From:
To: [DCAdmin](#)
Subject: Castle Hill Study - Grounds for objection re 2018/93591
Date: 13 January 2020 21:59:04

Castle Hill Setting Study

Drawing
 Proposed Section AA & Section BB

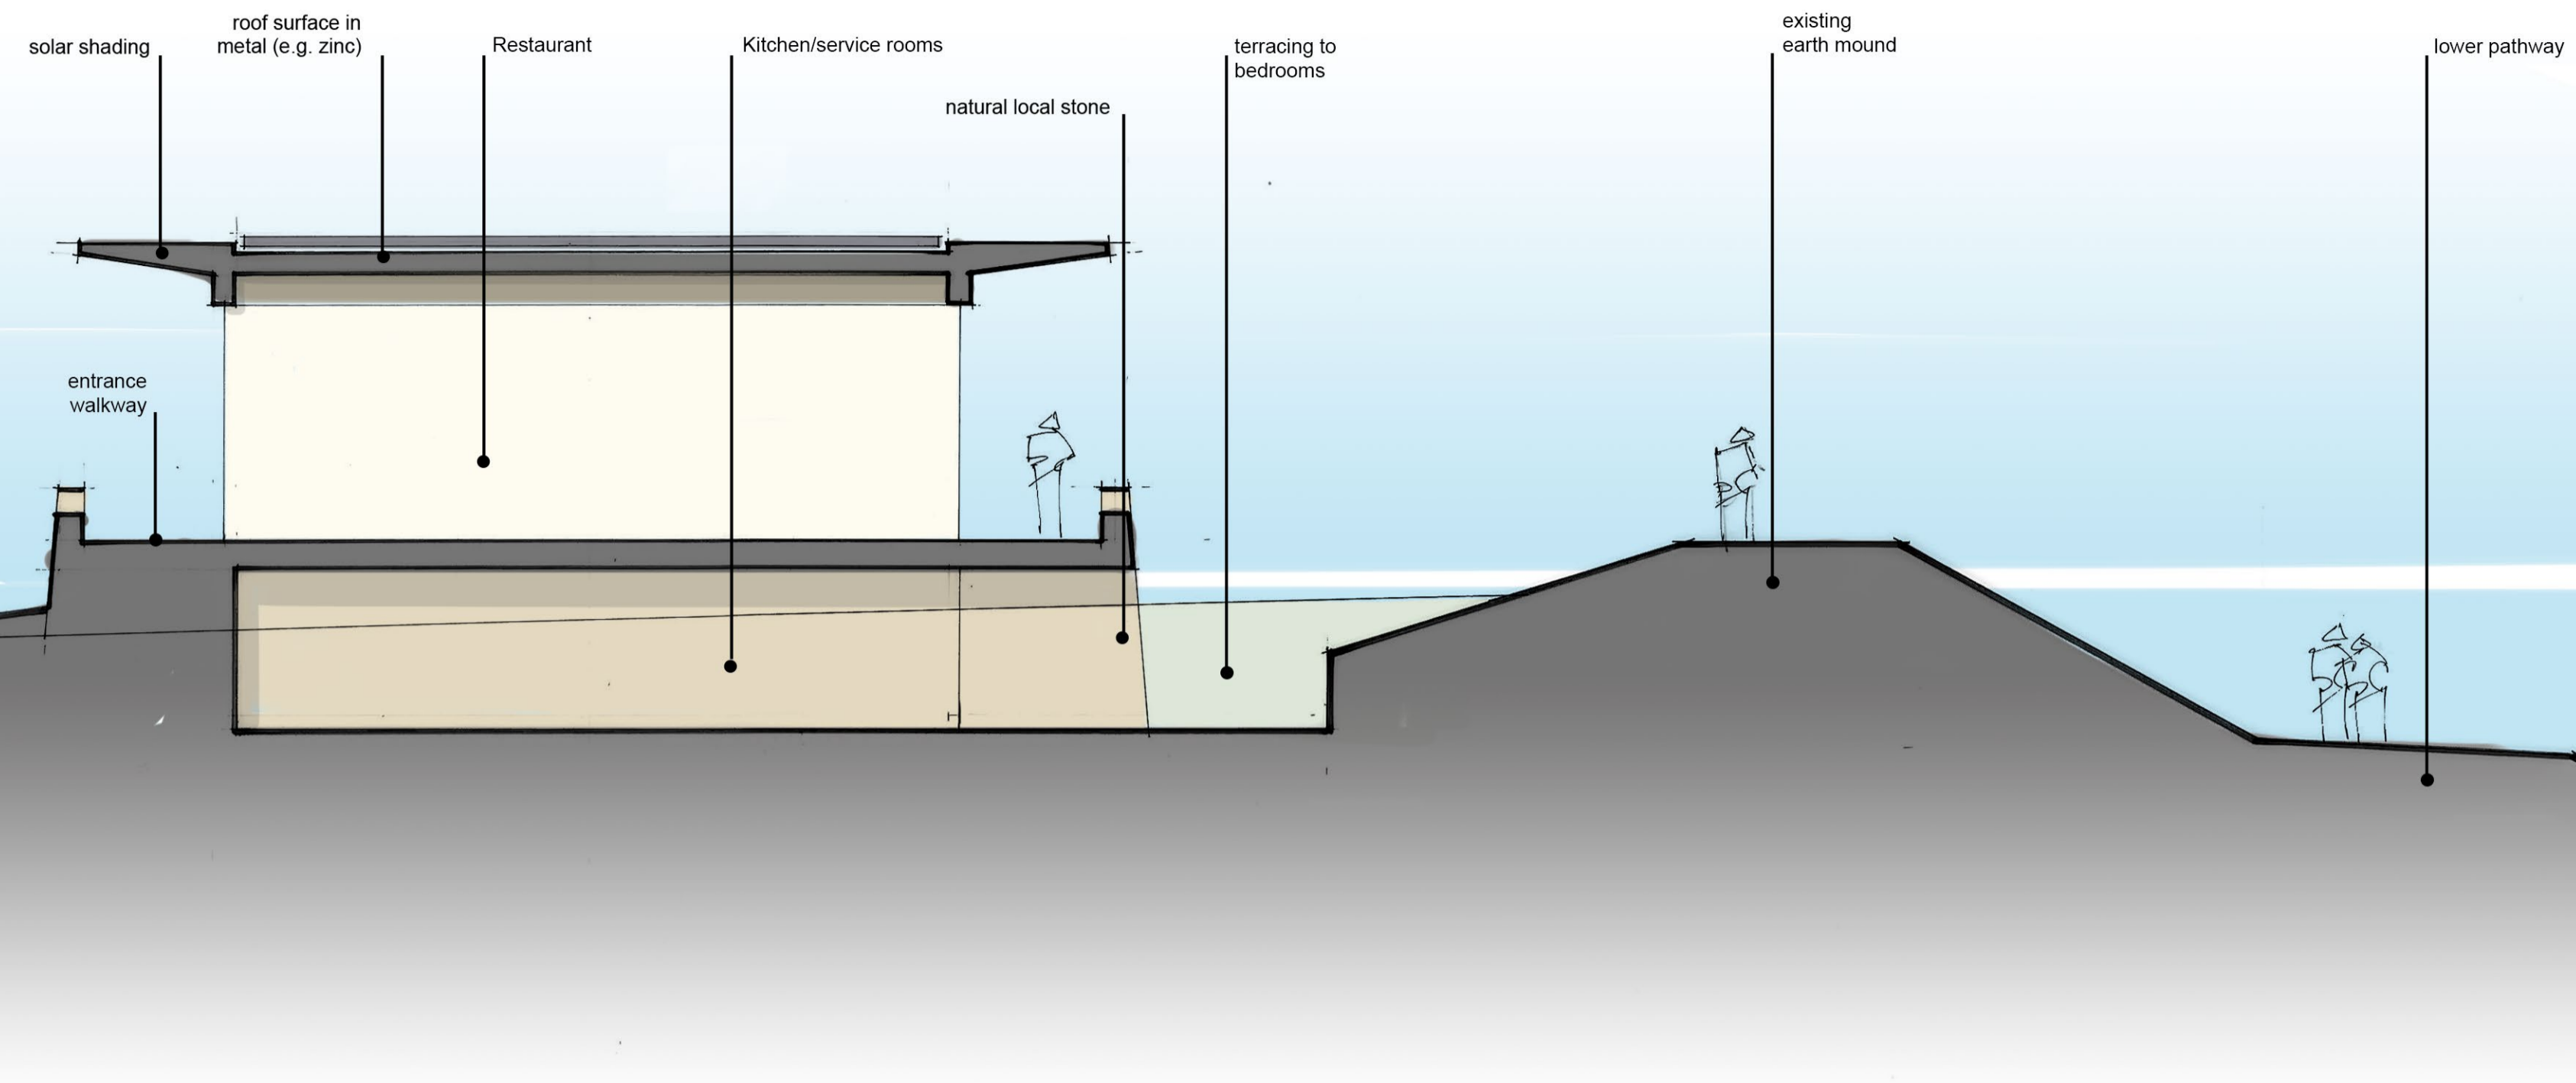
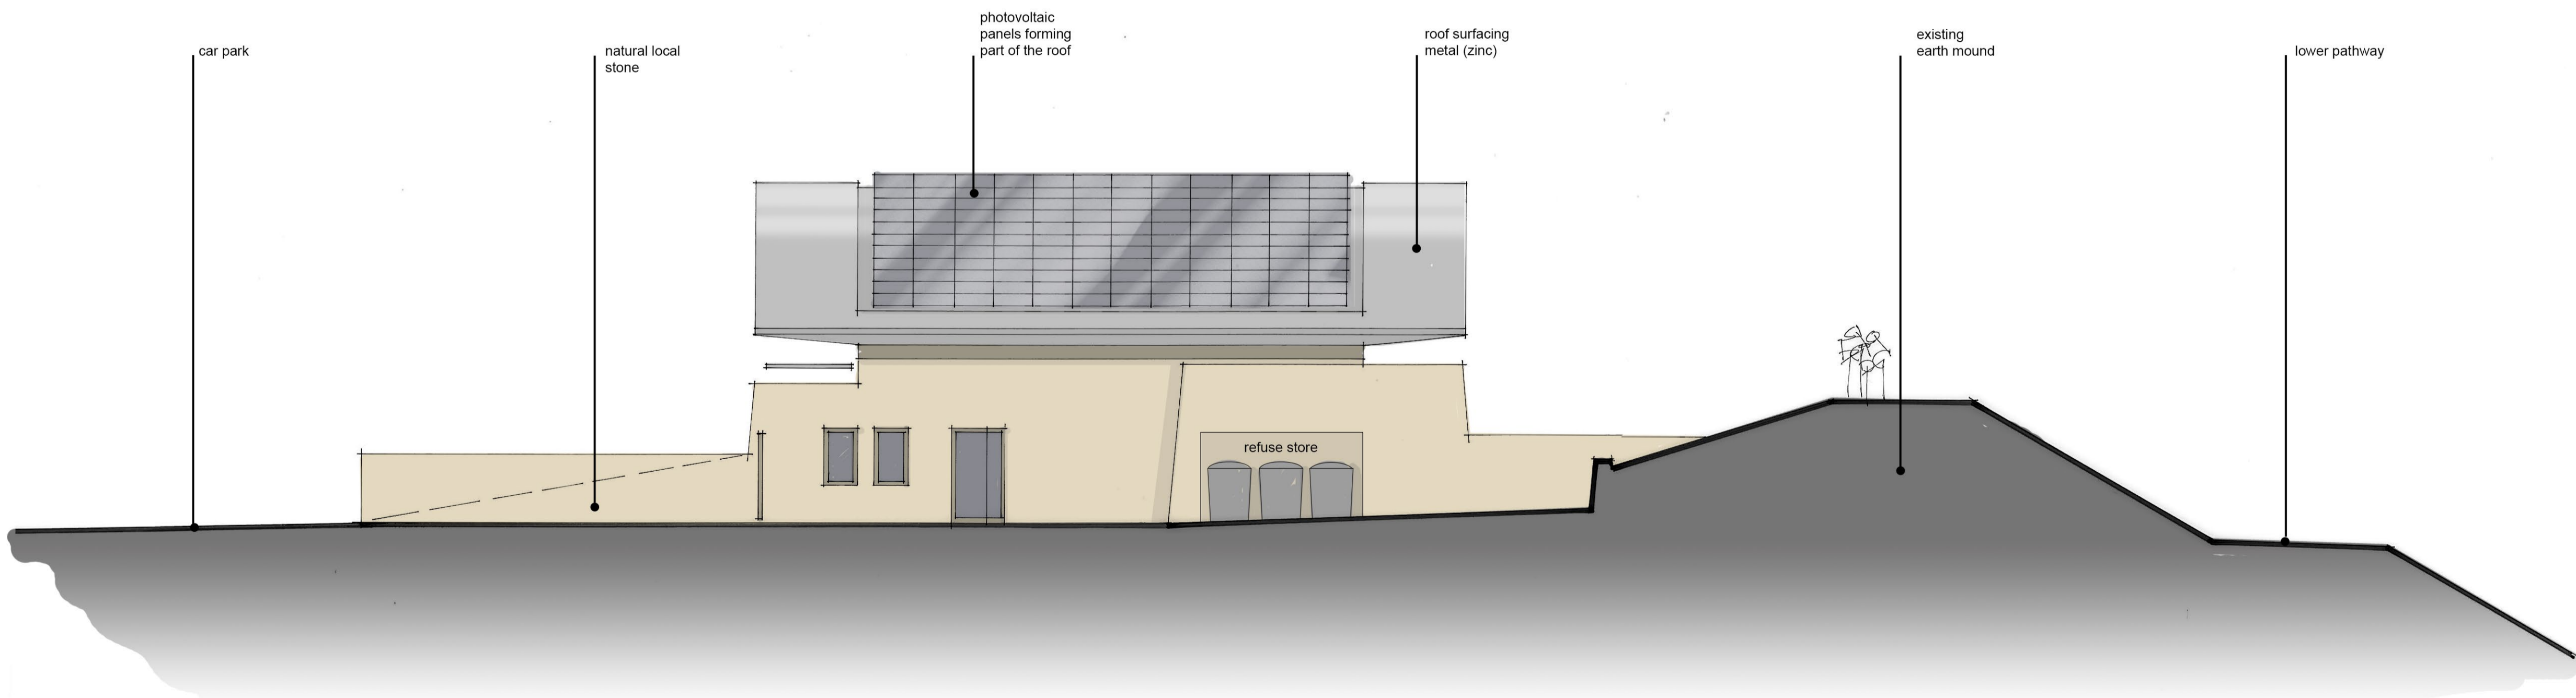
The drawings show a 3 floor structure where the 2 levels below ground represent a volume of at least 3 times that of the floor above ground. Whilst datum heights are not provided, it is clear the development will either lift the height of surrounding land unacceptably (damaging the open setting of Castle Hill and its victorian tower) or involve deep excavations over a very significant area of the site causing harm to the scheduled monument.
